facsimile transmittal

To: Michael Cloutier **From:** Mike Nugent
Fax: **Date:** November 19, 2002
Phone: 799-6232 **Pages:** 1
Re: 50 Tidemill Rd. (212 A058)

I have commenced the review of the above project and have the following comments:

2ND FLOOR PLAN

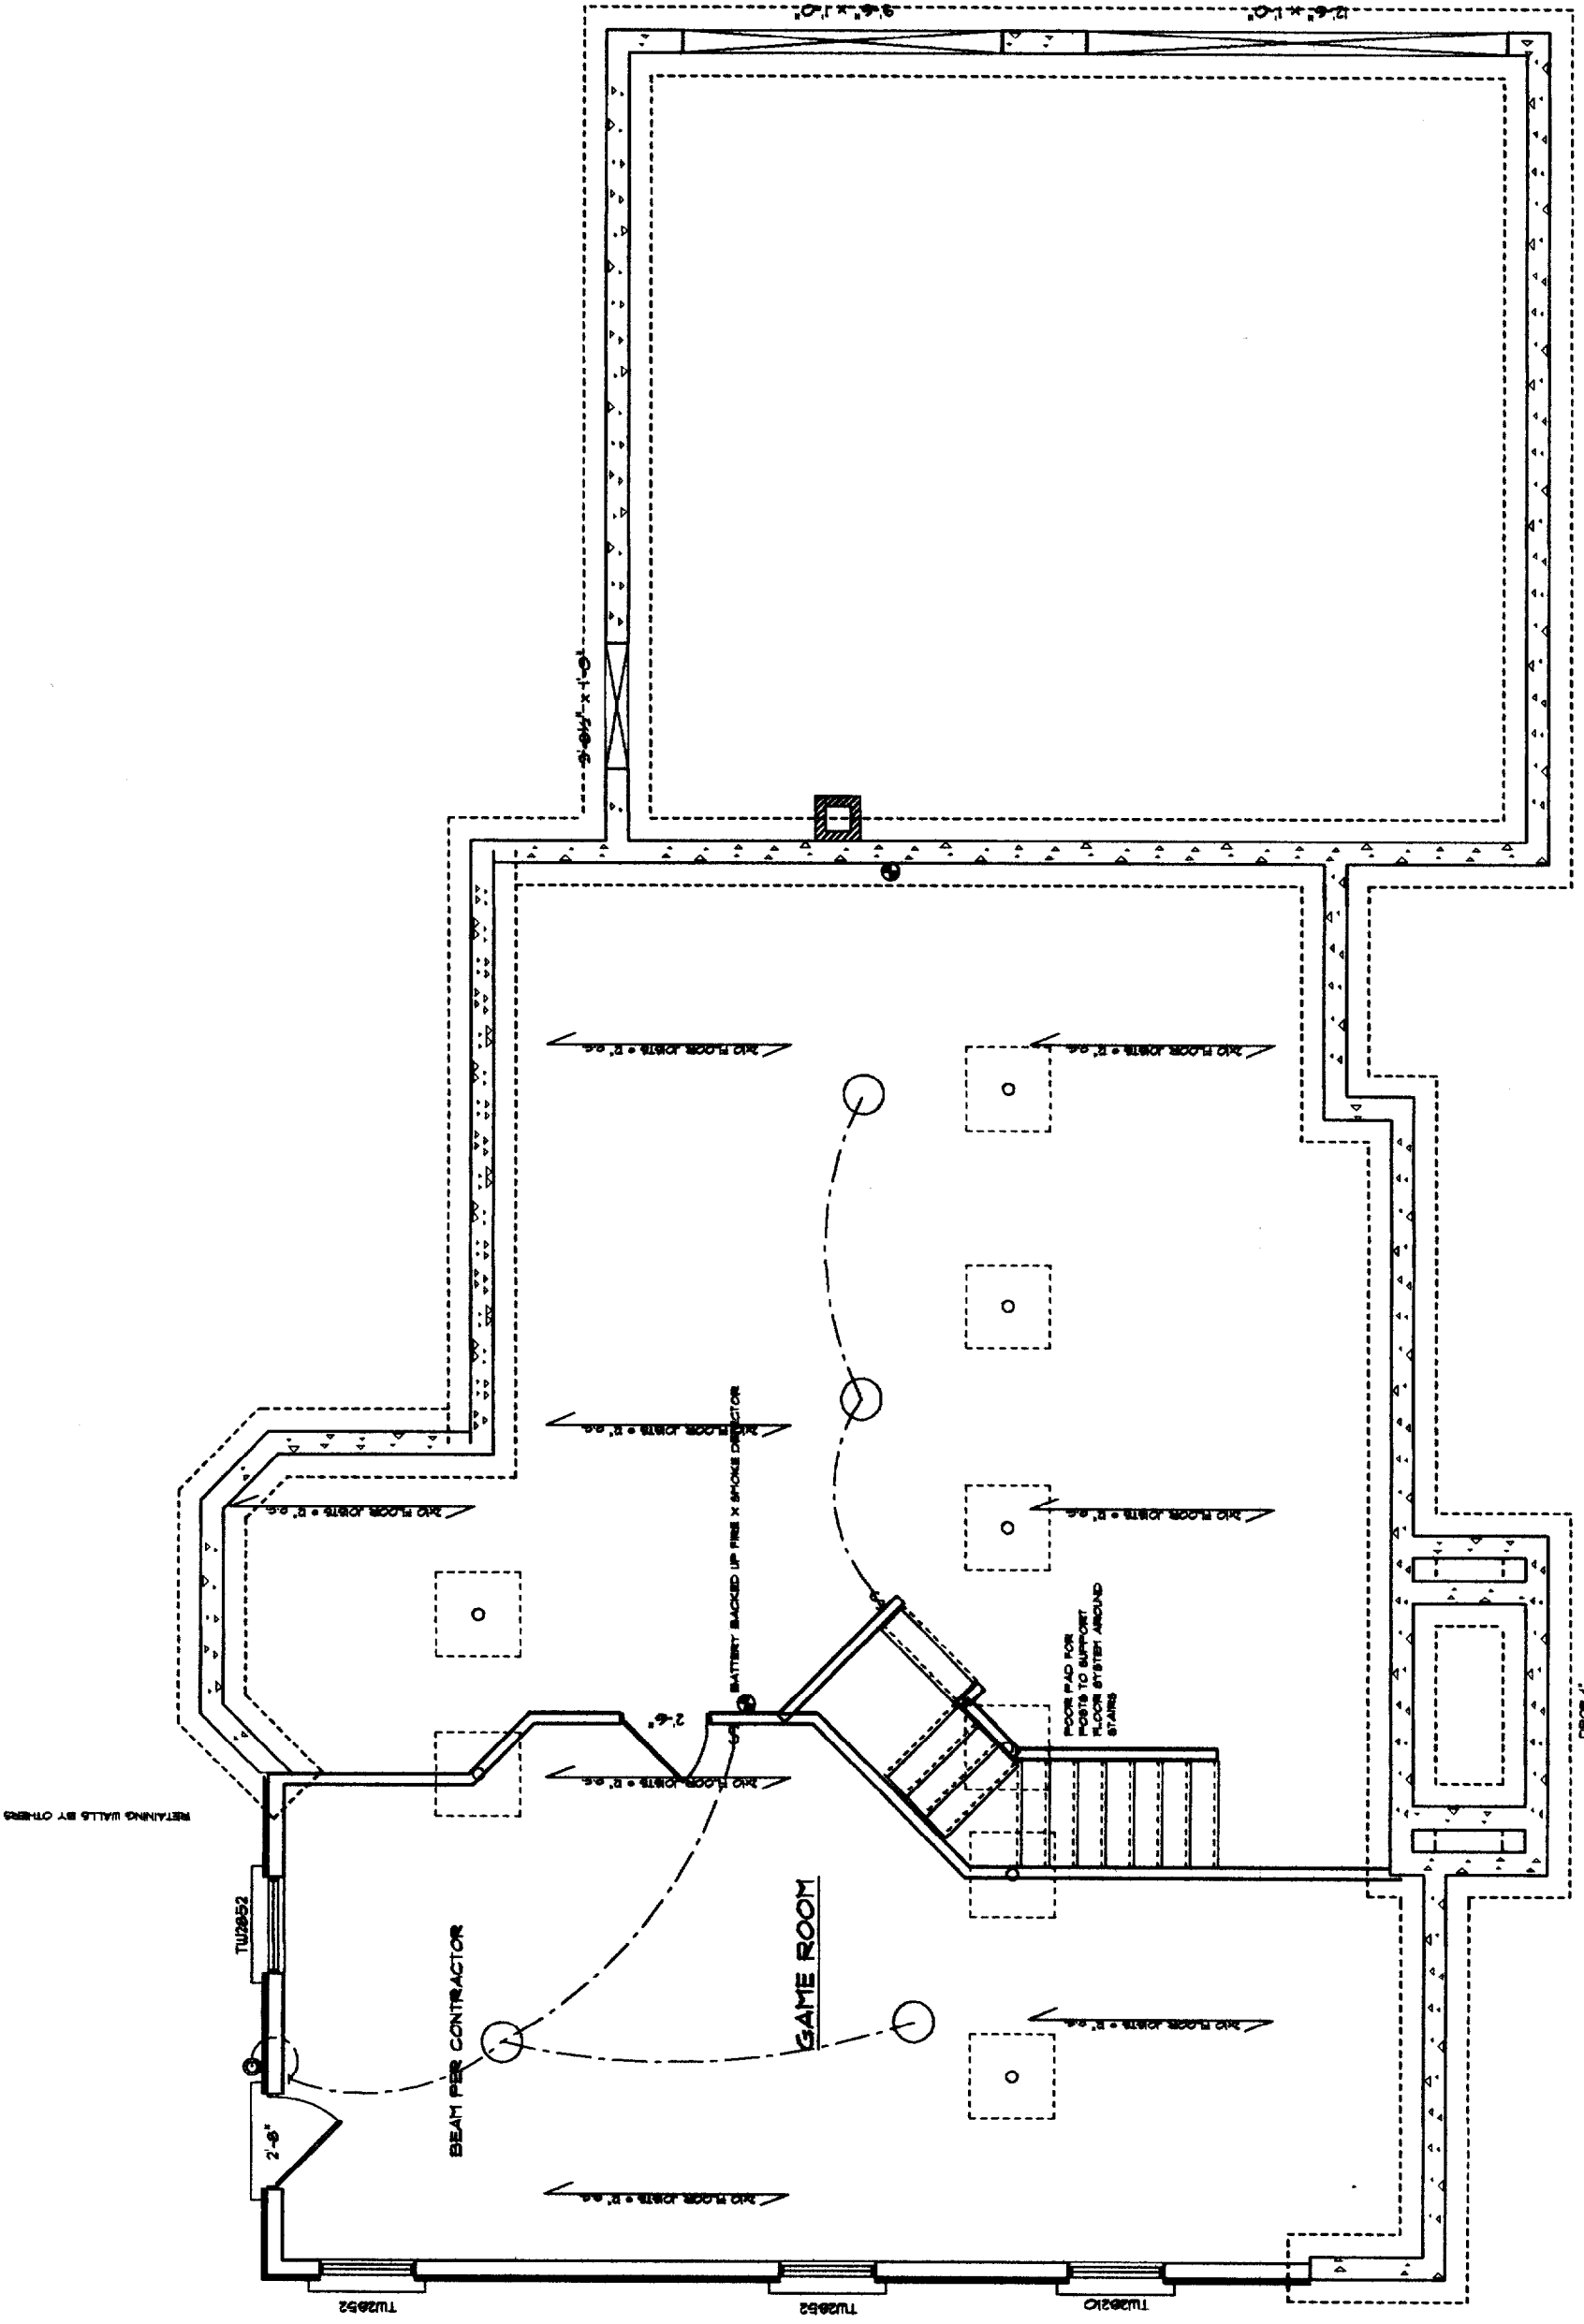
- 4) Need complete details of flooring system
- 5) Filter Fabric is not shown on the foundation drain, it is required.
- 6) Sill & Band joist not spec'd
- 7) Second Floor joists 12" or 16" o.c. it says either or, what will it be

FOUNDATION PLAN

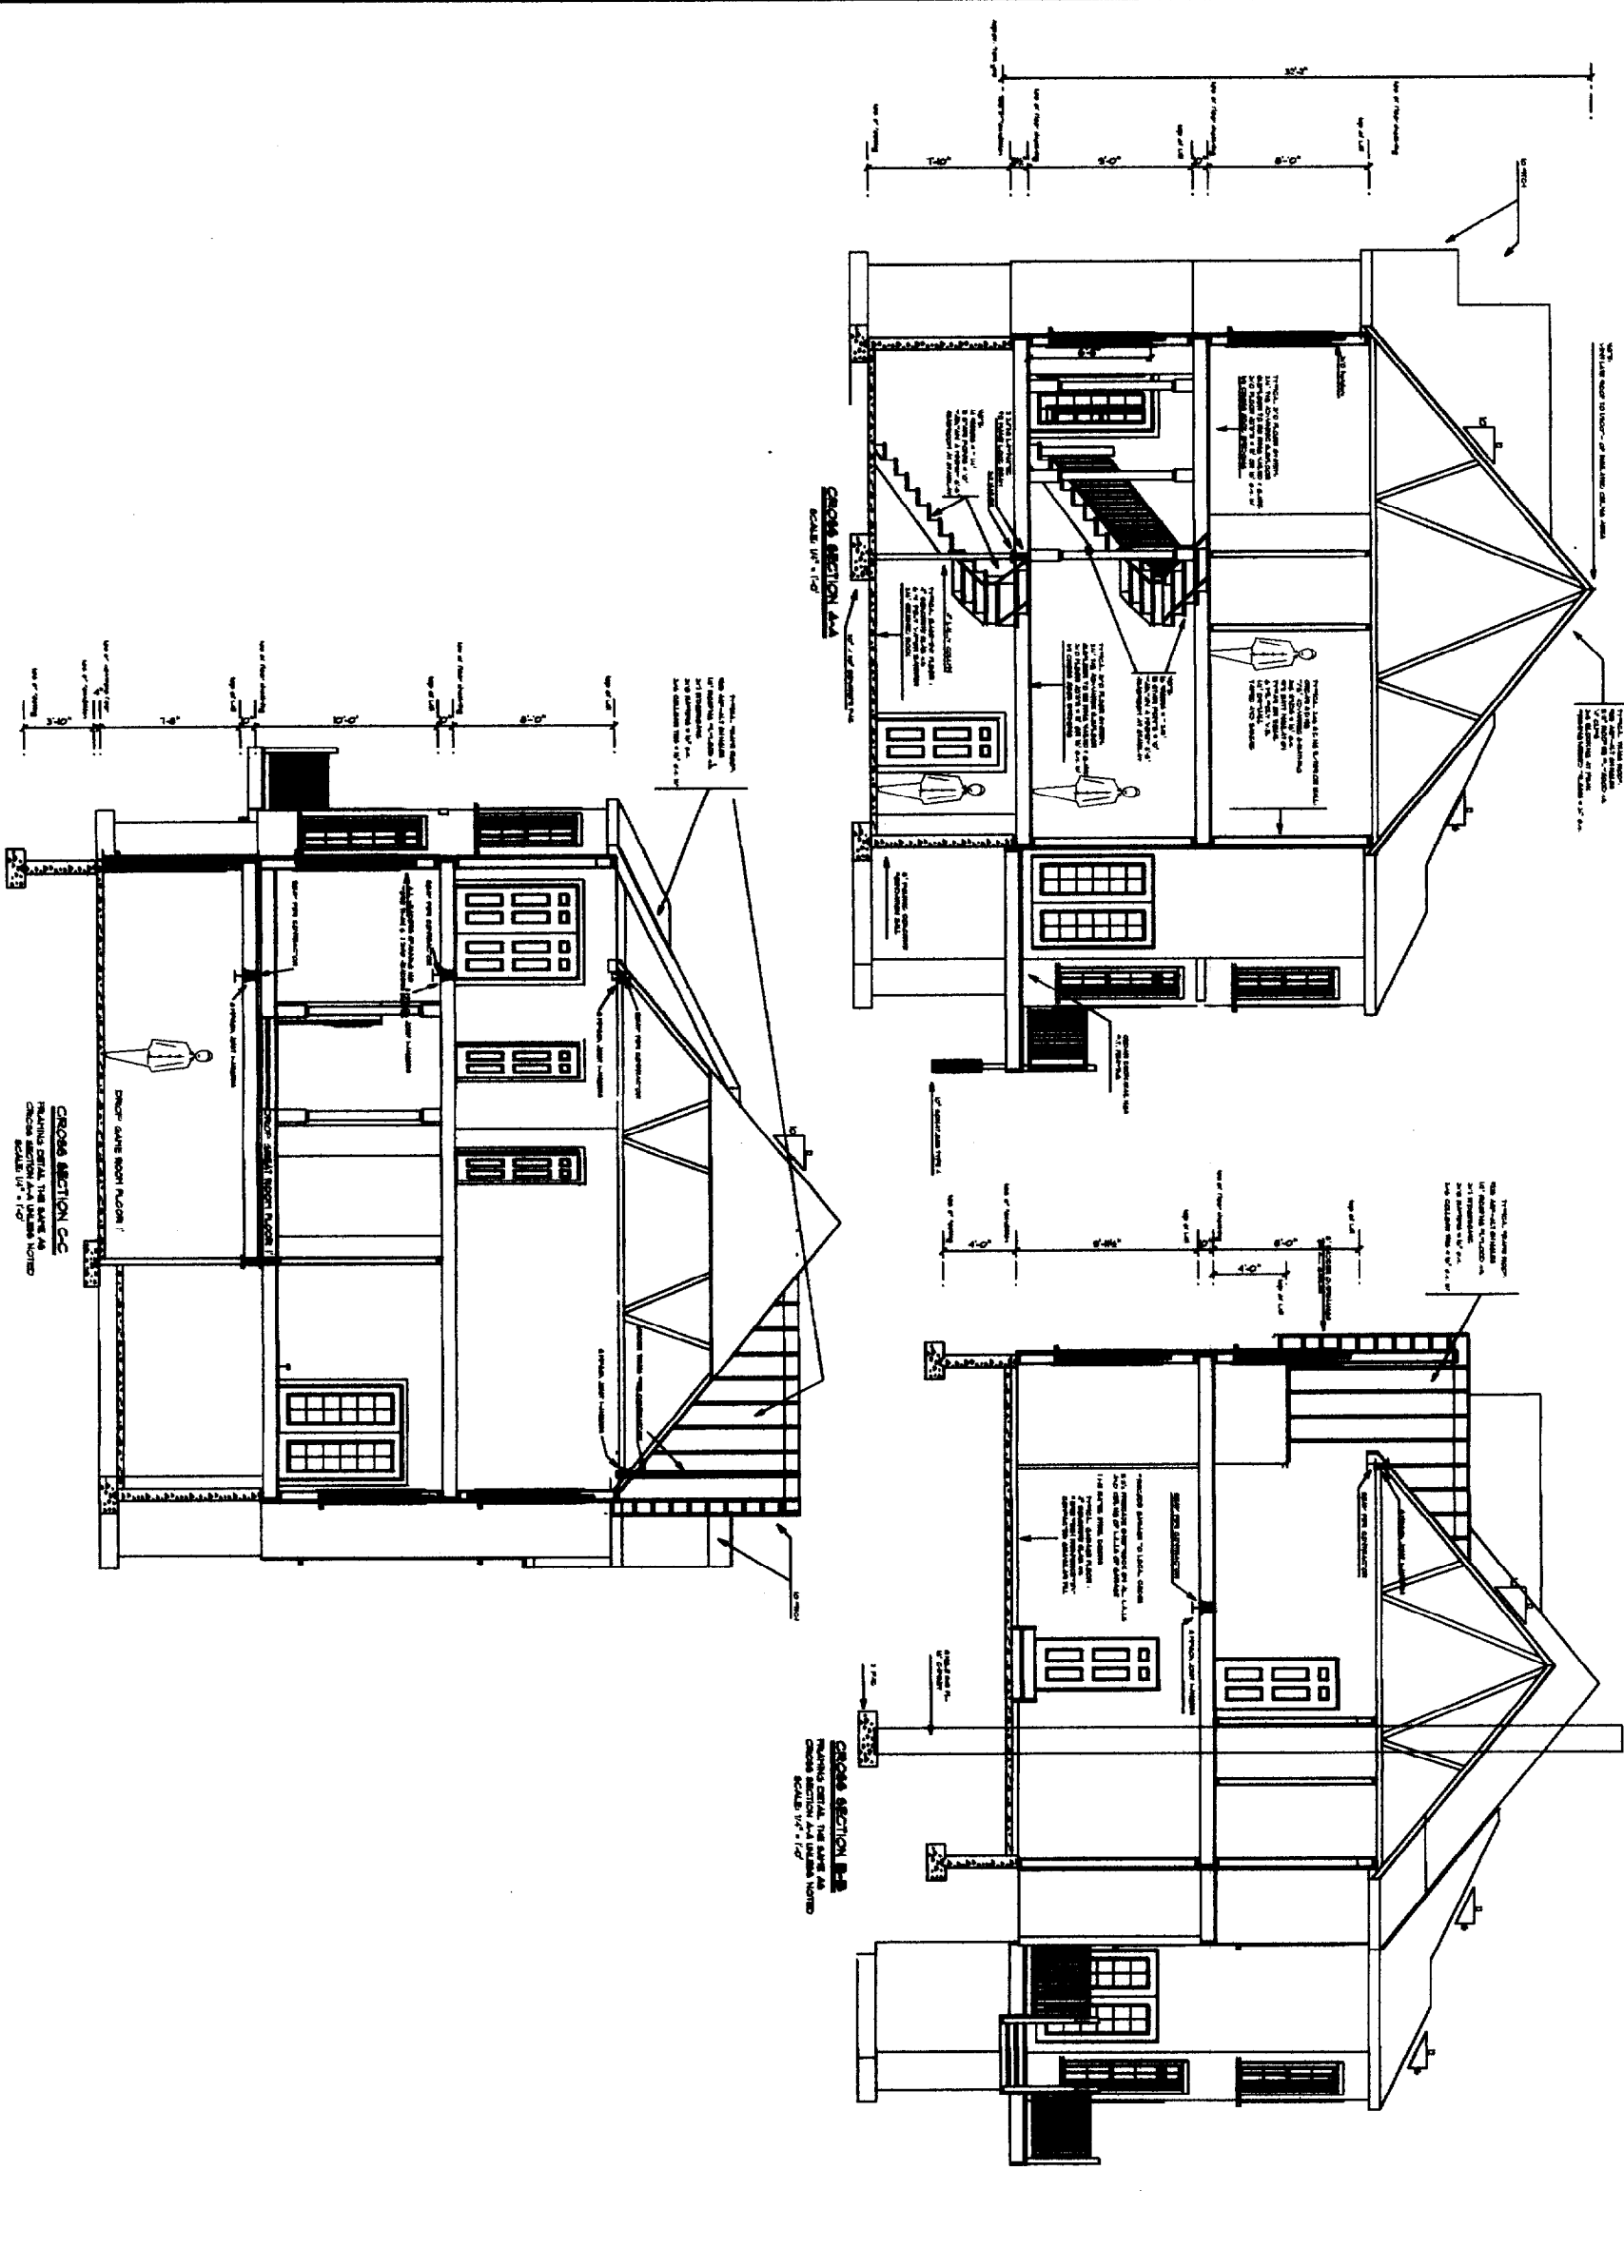
- 1) What is the soil profile on the lot?
- 2) The footings are less than 4" below grade in the garage.
- 3) The footings for the Lally columns are show as 24" and 30" which will it be.
